Shannon Hernandez Macintyre
7520 Mercer Terrace Dr, Mercer Island WA, 98040

Date: April 19, 2024

Mercer Island Permit Number: 2402-026

We are the structural engineers of record for this project. This letter lists the comments related to the structural design and what was done to address each comment.

ADDITION SECTION & DETAILS

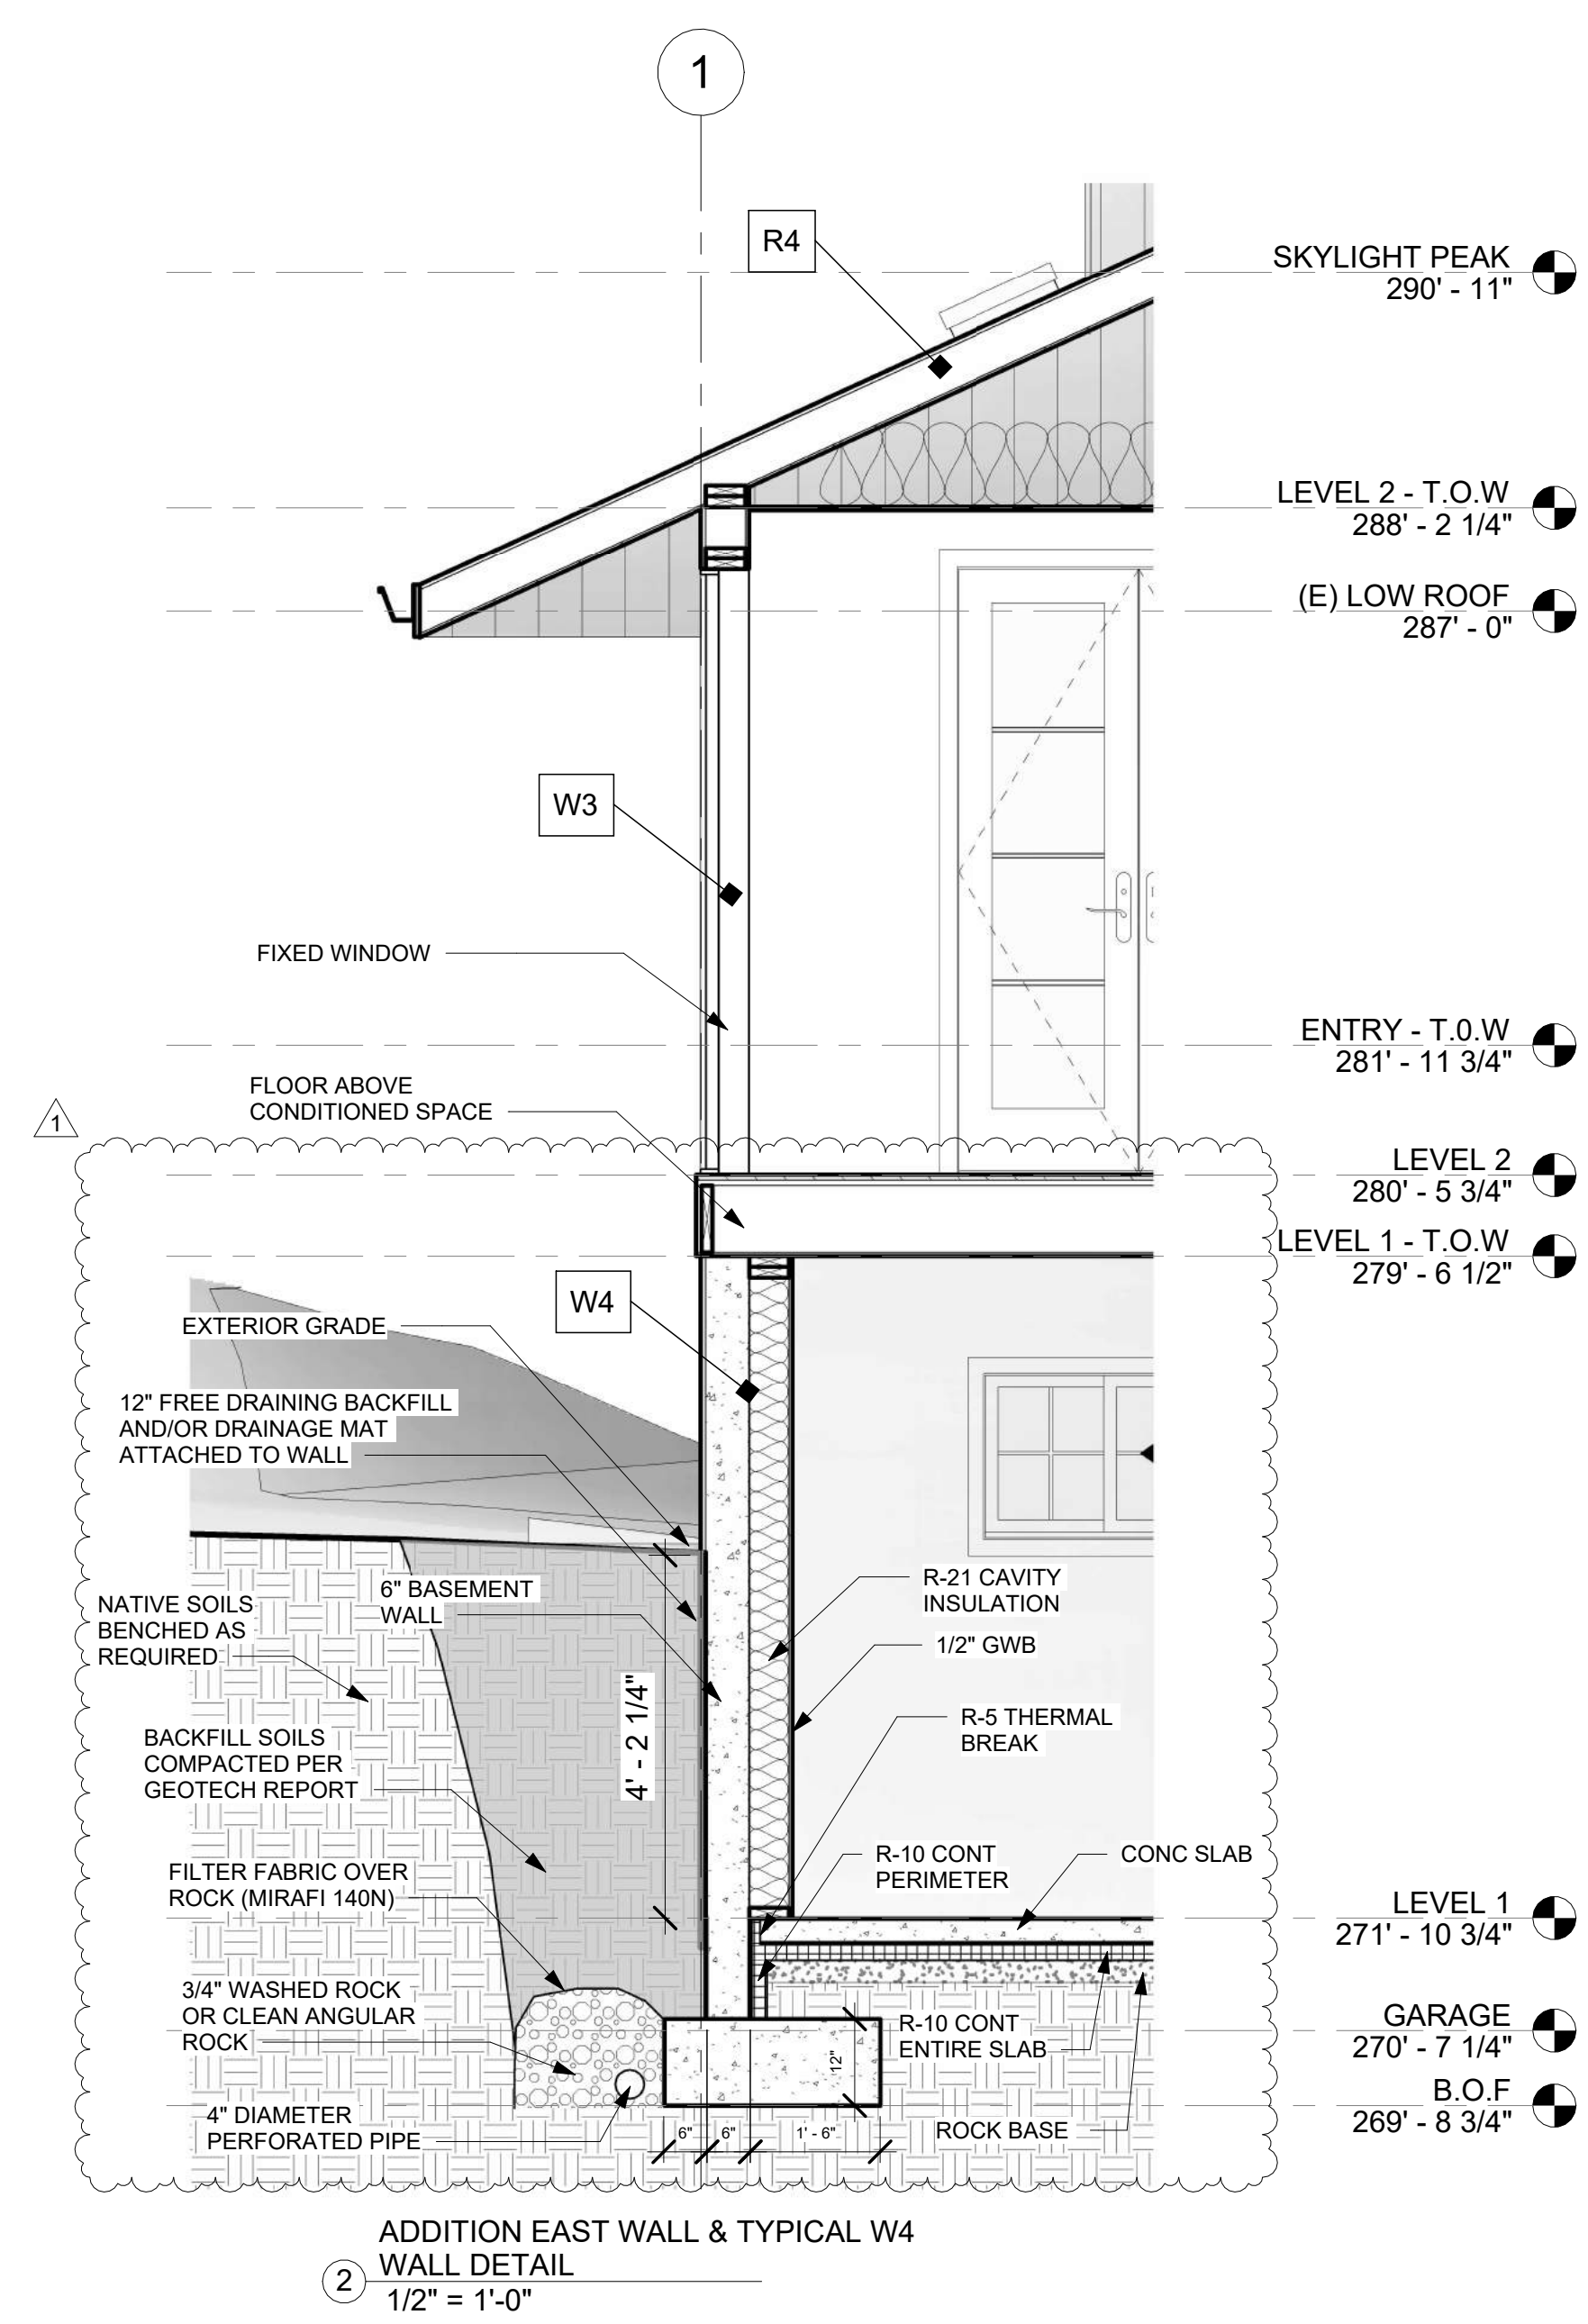
F2? Please provide detail or correct

Detail F3 shows an exterior footing with slab, this is the correct condition for this foundation according to sheet A303 of the architectural plans.

S-5

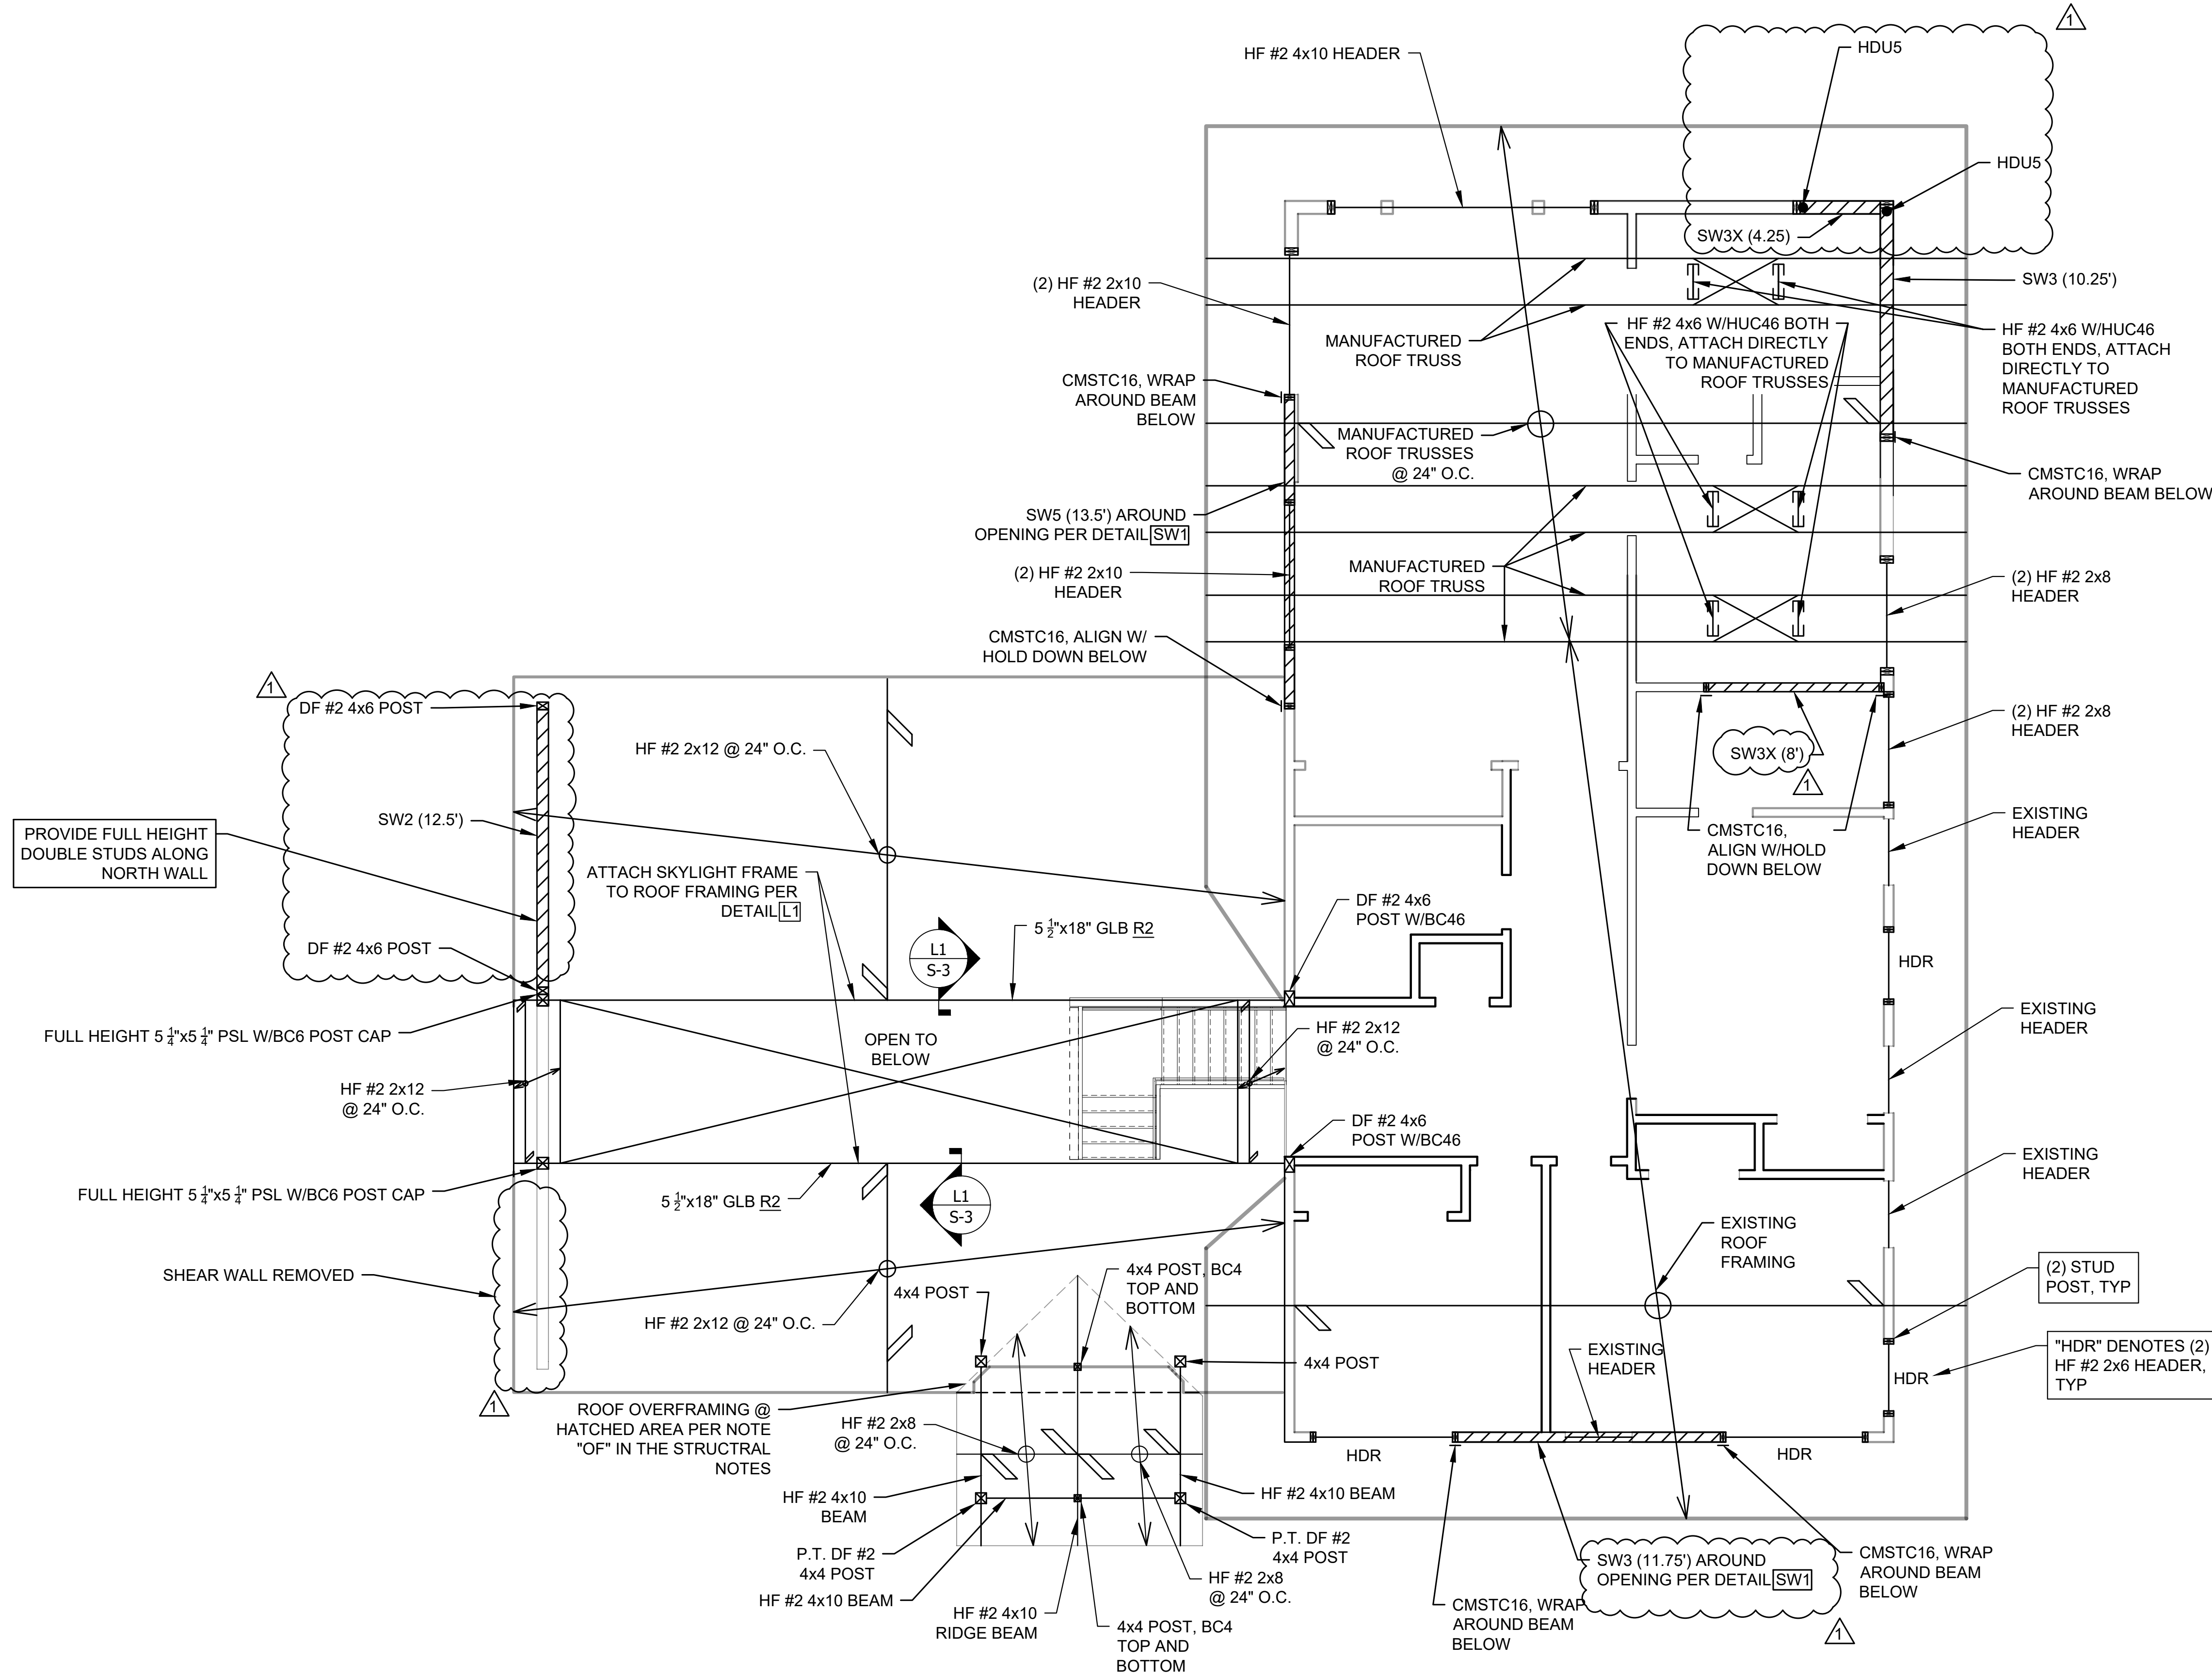
Add Kzt value used for new construction design to Design Data. Calculations show $Kzt=1.38$ on cover page and 1.0 in L1. Site appears to fall in $Kzt=1.6$ region on Mercer Island Map: Provide topography-specific calculation of Kzt for all directions to justify use of Kzt less than 1.6. Revise loads and lateral system design for any wind-governed components or detailing. Specify calculated or prescriptive kzt at all locations to match.

The Kzt value listed on the structural calculation cover page, sheet L1, and the structural notes of the drawing set has been updated to $Kzt=1.6$. Likewise, calculations on sheets L2-L6 have been revised to reflect the updated Kzt of 1.6, the shear wall schedule on sheet S-1 has been updated accordingly, and the lateral design on sheets S-5 and S-6 has been revised as needed to comply with the new Kzt value of 1.6.
